**State Environmental Planning Policy (Transport and Infrastructure) 2021**  
**State Significant Development Application - SSD-87486461**  
**20-22 Atchinson Street, St Leonards**

16 December 2025

SSD-87486461 – 20-22 Atchinson Street, St Leonards

| PLAN No.: 210492-1_REV.C | DATUM: AHD |

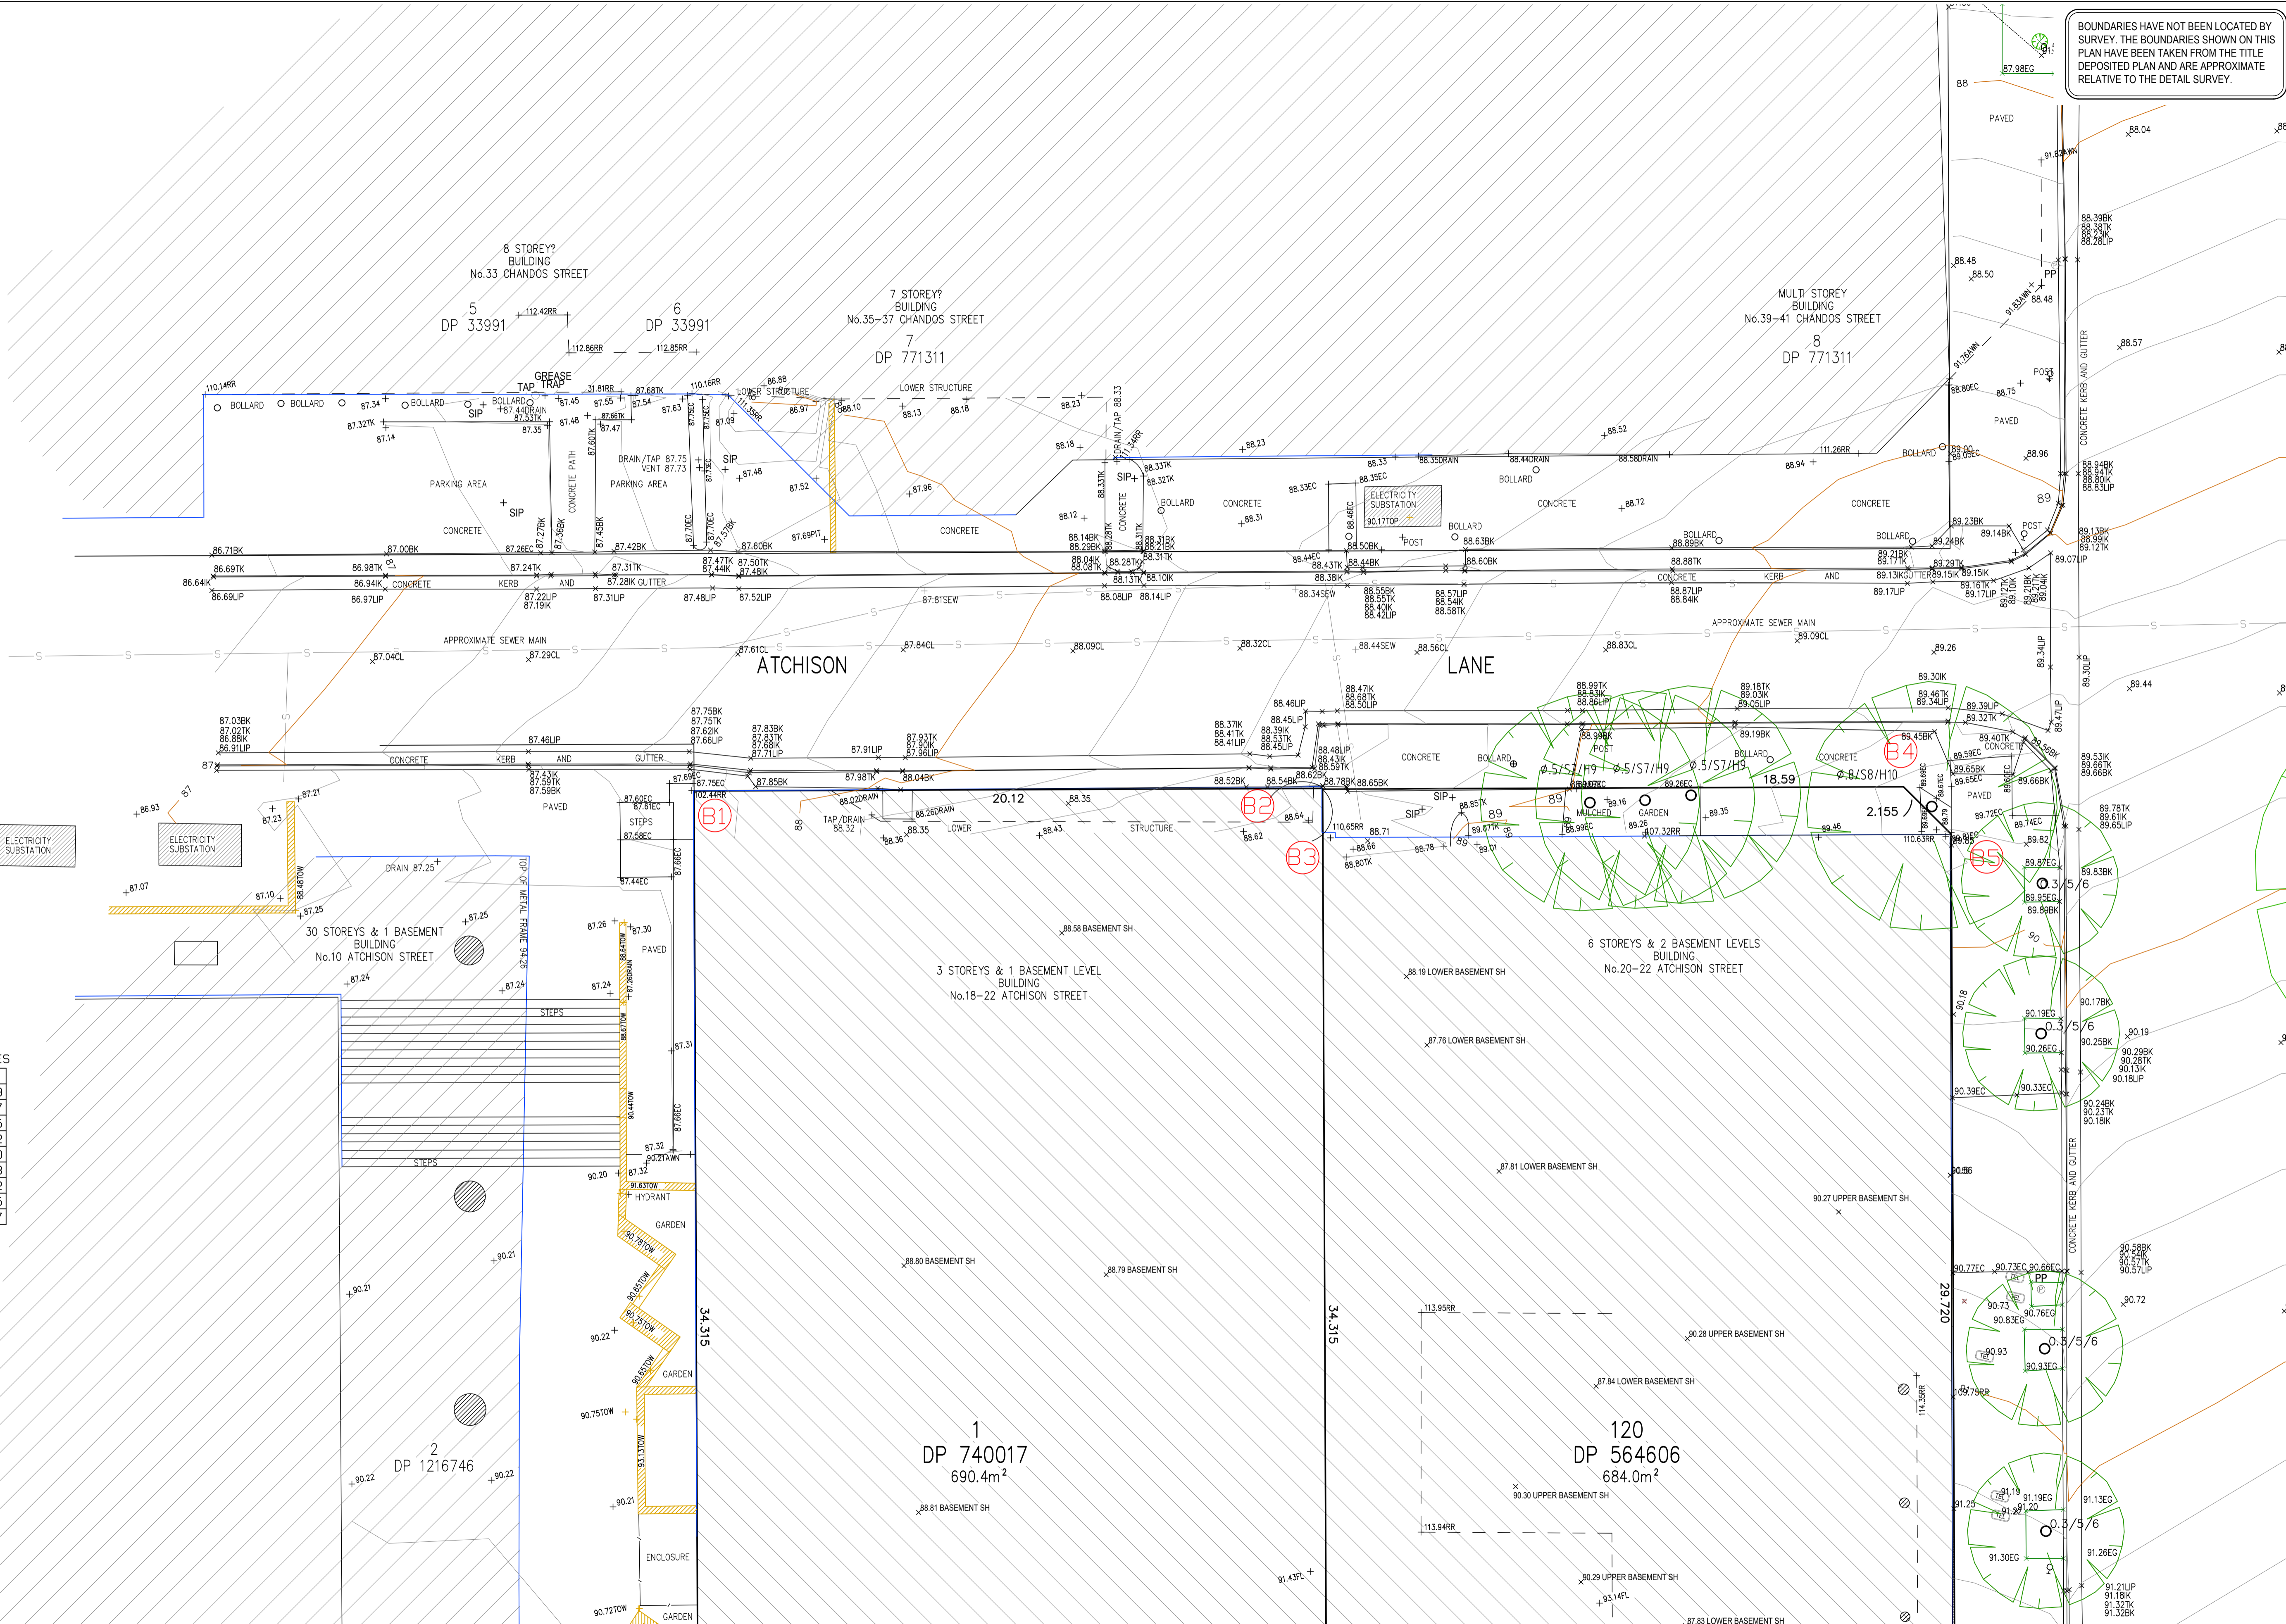
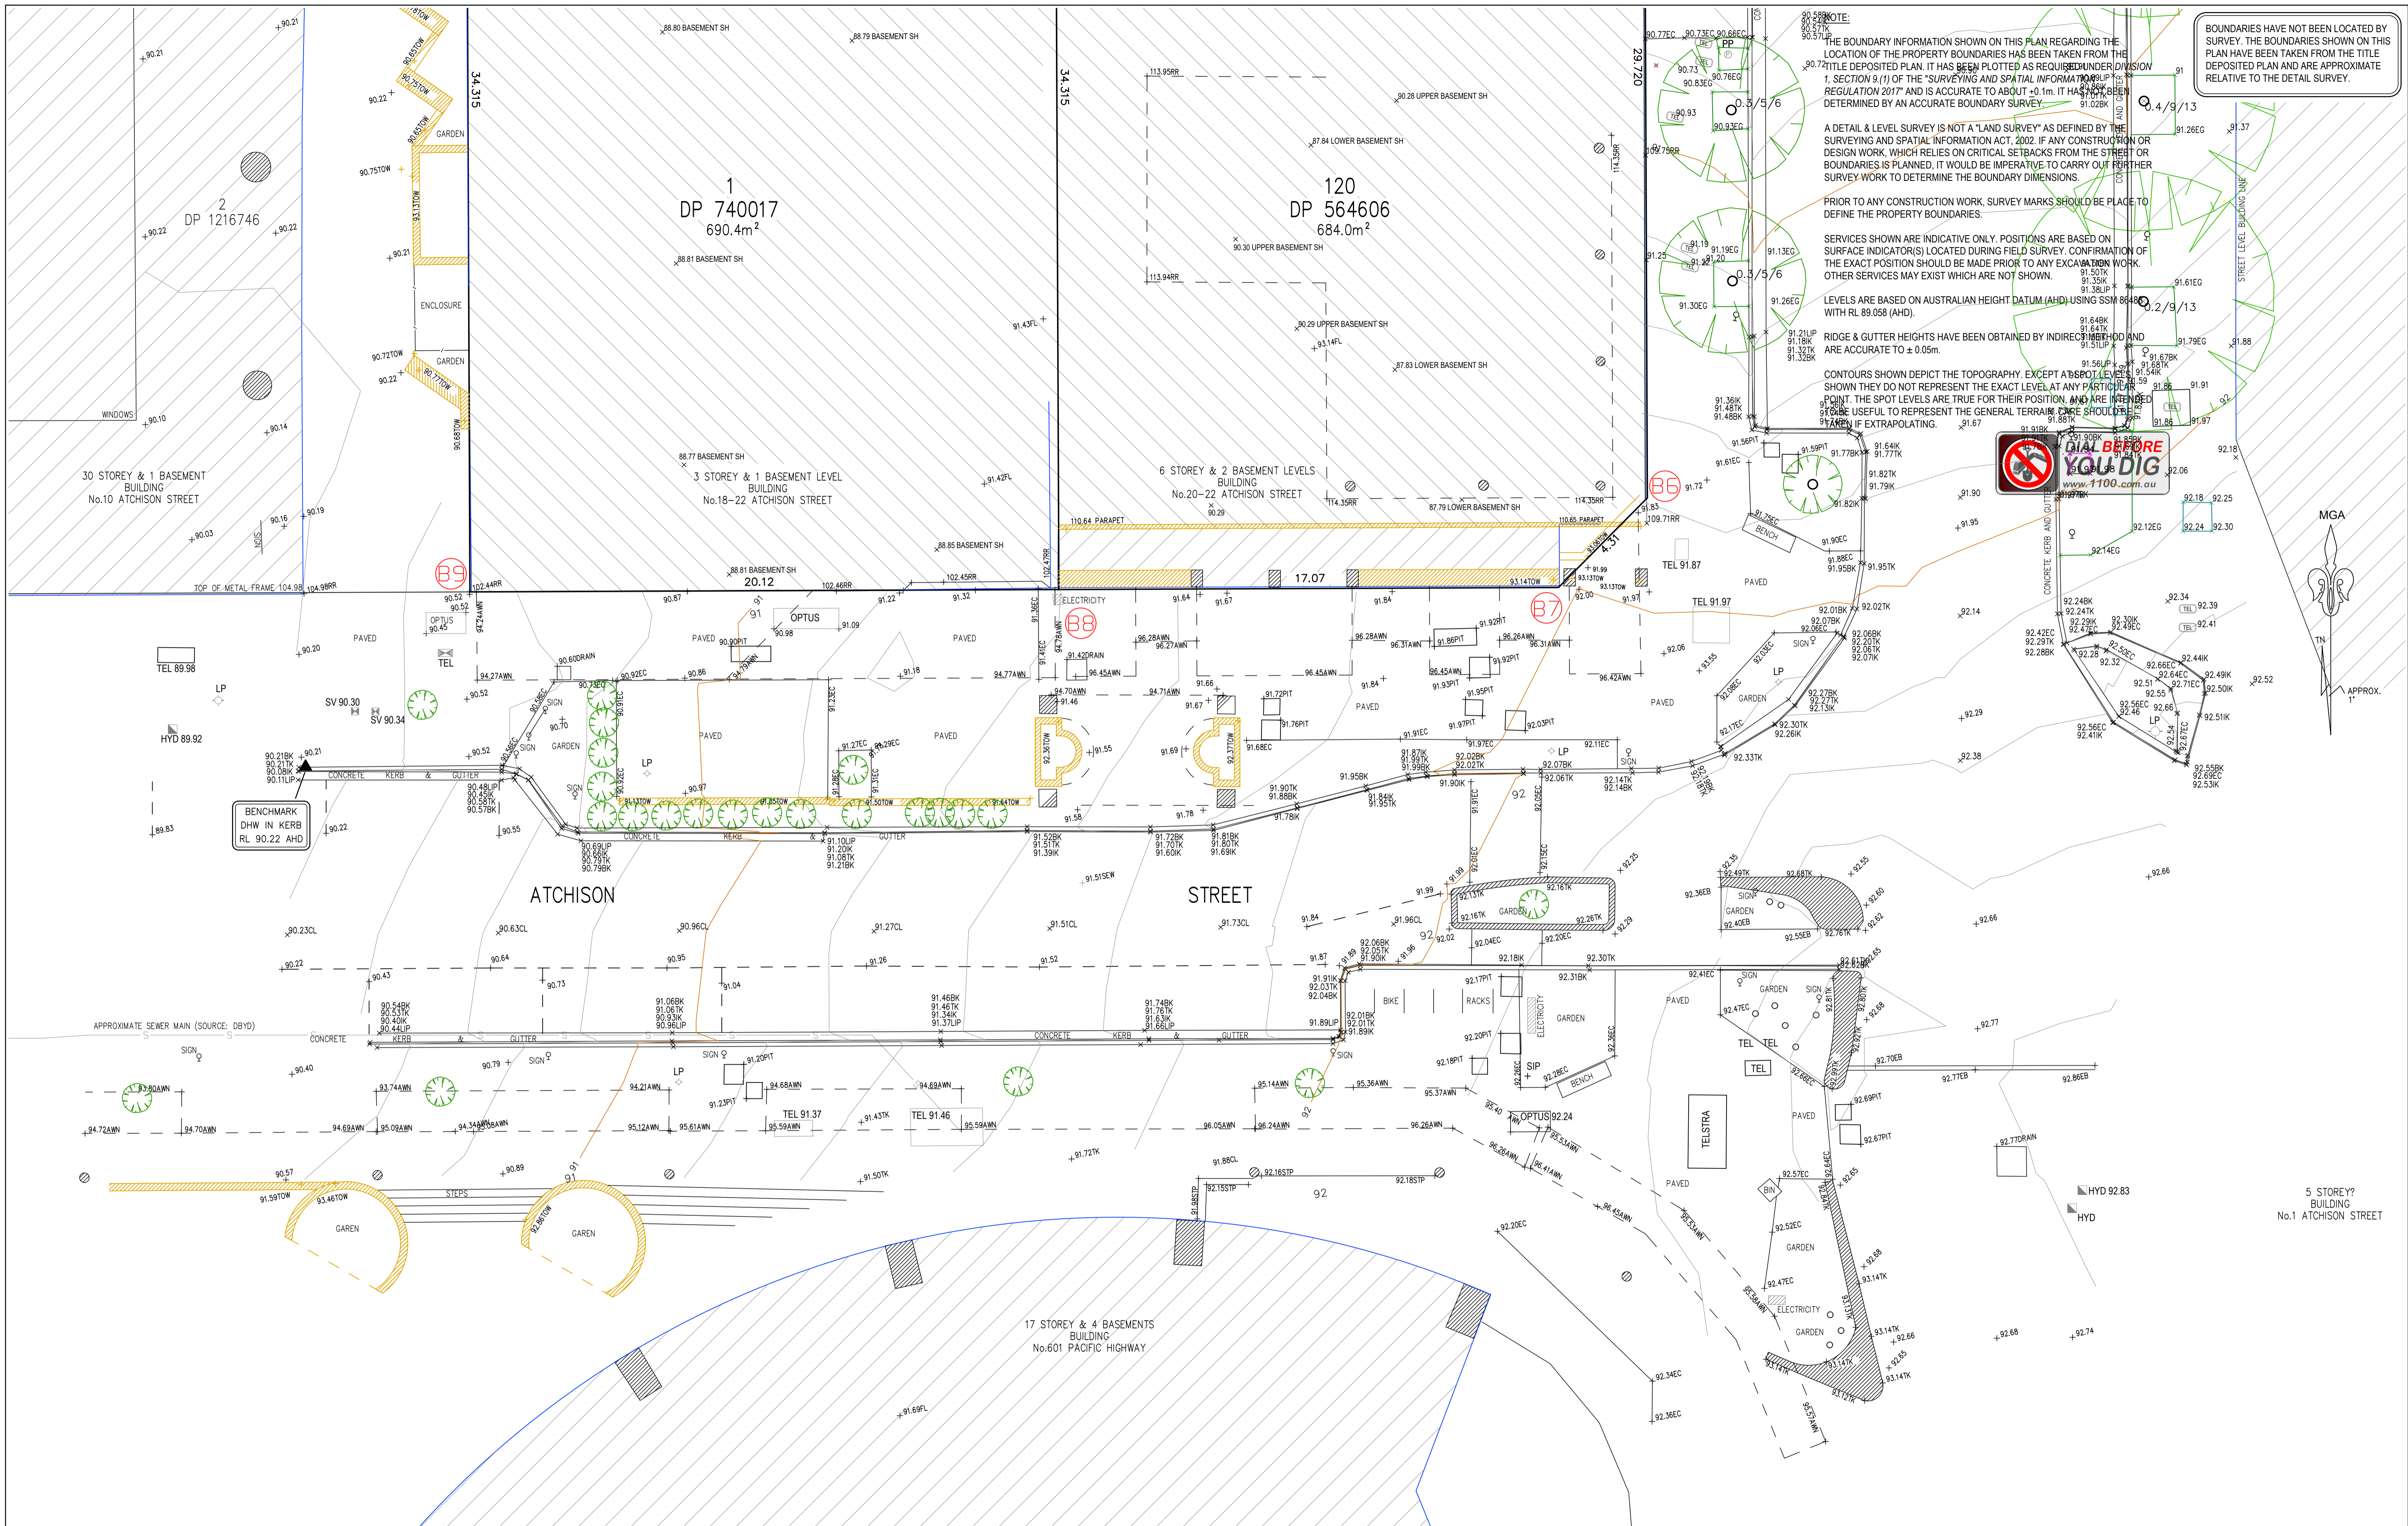
- detailed survey plan and critical sections prepared by an NSW registered surveyor which accurately defines the boundaries between the Development and:
  - the rail corridor (including Sydney Metro First and Second Reserves)
  - rail infrastructure and utilities

Figure 1 – Location of Metro Corridor relative to the development

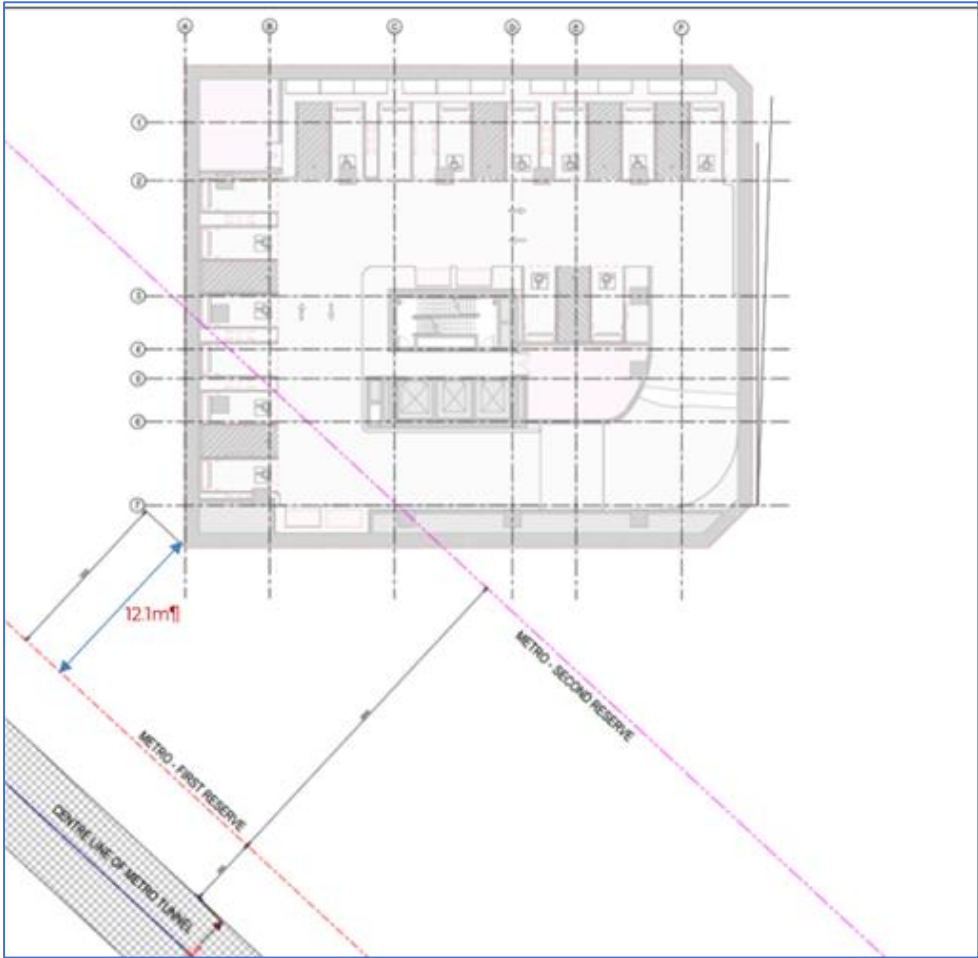
- plans and sectional drawings of structural design, including details of Development footings and the geometric relationship to first and second reserves and Sydney Metro infrastructure.

- shoring design details, including confirmation of whether any ground anchors are proposed within the second reserve of the Sydney Metro running tunnels.
